FURTHER TO ORAL SUBMISSIONS AT ISH7

Important Hedgerows and Tree Preservation Plan Sheet 2 / Important Hedgerows 3 & 4

Hedgerows, Flora, Fauna in and bordering Plots 10; 12;13;14

| Important Hedgerows and Tree Preservation Order Plan Sheet Number: Sheet 2 of 12 | | | Rev | 5 | British National Grid OSGB36 |

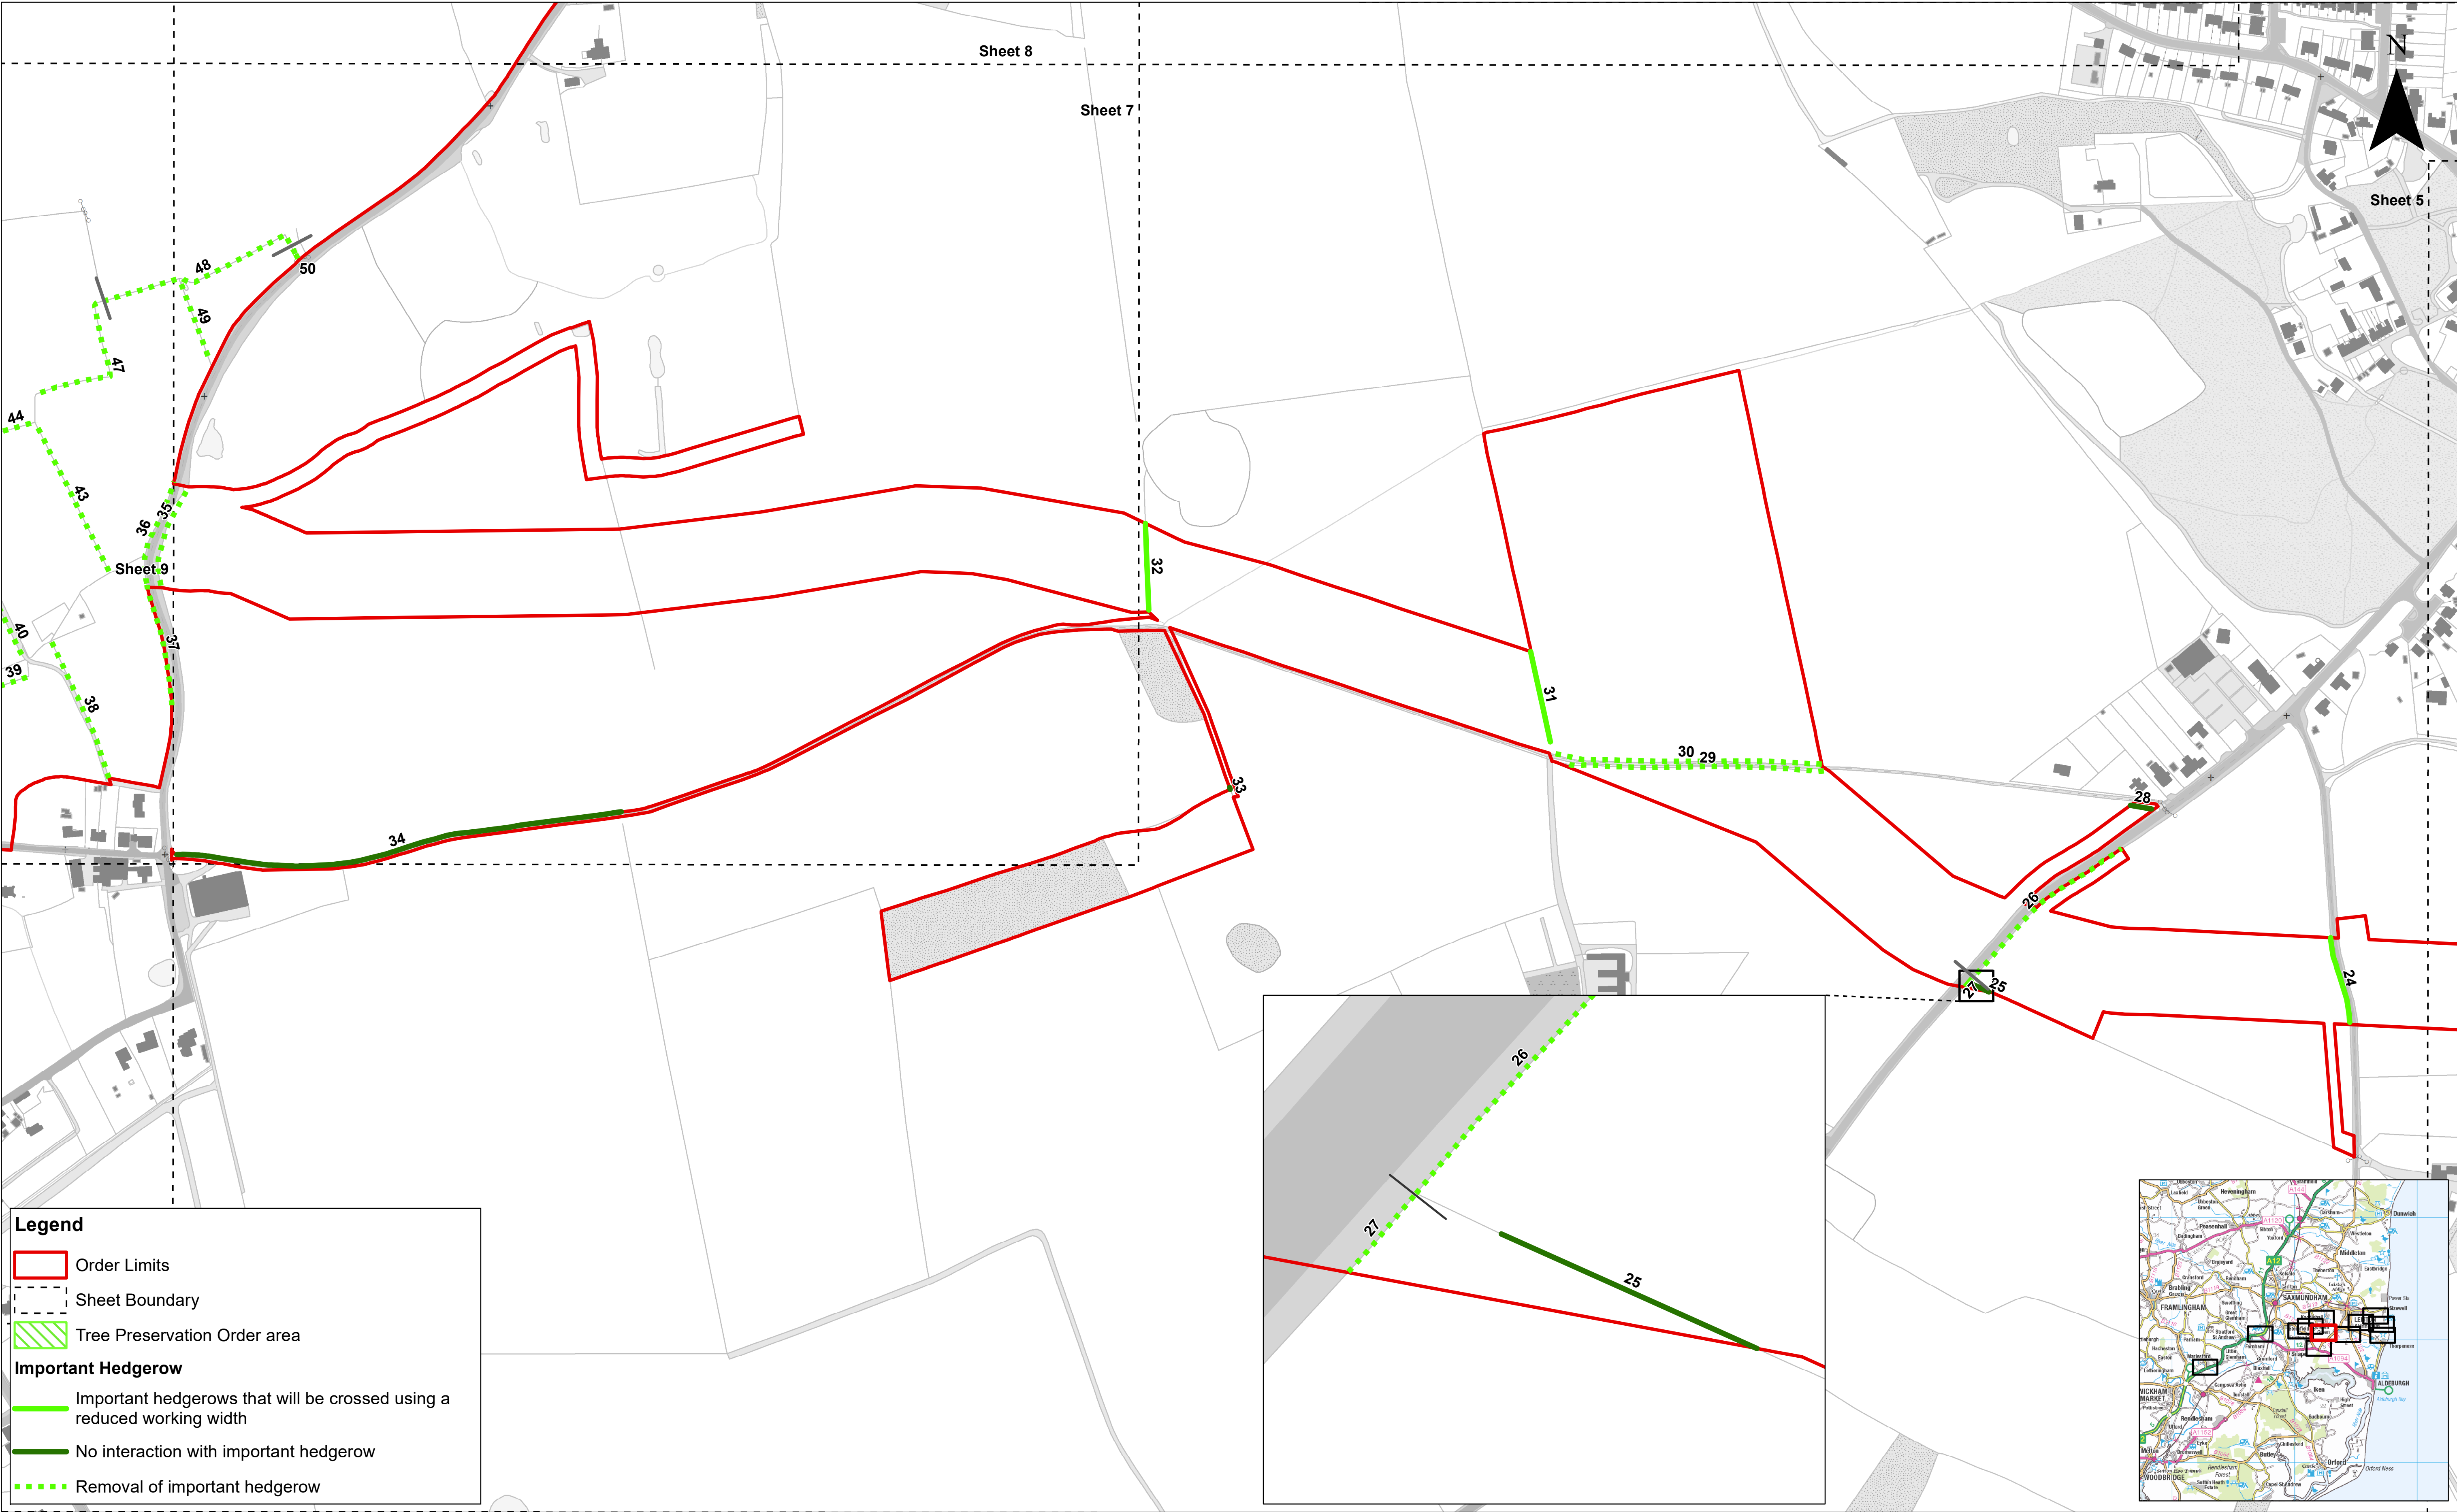
During ISH7 / Biodiversity, the Applicant's representative, when questioned regarding surveys of soil, geology, flora and fauna with regard to the areas cited above (10;12; 13;14;) made frequent reference to "a suite of surveys" having been carried out, but to date no surveys have yet been carried out in the areas I cite. Rather, the areas in and around the proposed sub-station at Friston, the Hundred river, and associated plots seem to have been concentrated on.

Could the Applicant please be questioned again as to the date and extent of any surveys specifically undertaken on plots 10;12;13;14? Surveys undertaken some miles away can have no relevance to this area. Furthermore, in concentrating what survey work has been undertaken on identifying likely habitats for certain species, rather than recording the actual presence of such species, which has been independently recorded for many years, the Applicant has really done little more than have a quick look around, and failing, for instance, to stumble upon either the presence of the brown eared bat, or whatever the Applicant had deemed to be a viable habitat for such an individual, concluded that, contrary to extensive local reportage, no such species is present. Without wishing to be trivial or vexatious in any way, one really is reminded of the legend of Admiral Lord Nelson at the Battle of Copenhagen putting a telescope to his blind eye and declaring, "I see no ships"

In Important Hedgerows 3 and 4 (scheduled for demolition) and the associated hedgerows linking and bordering plots 10;12;13;14 more than 40 species of wild flower have been recorded (cf my earlier submissions which include species recorded by Wardens volunteers and trustees over several decades). Amongst these flora are Red Valerian; Honeysuckle; Petunia; Sloe; Hawthorn; and numerous nectar-rich flowers. The species I name here are of particular relevance to several rare and protected species; three examples: the Hummingbird Hawk Moth; Lampyris Noctiluca (the Glow-worm); Elephant Hawk Moth.
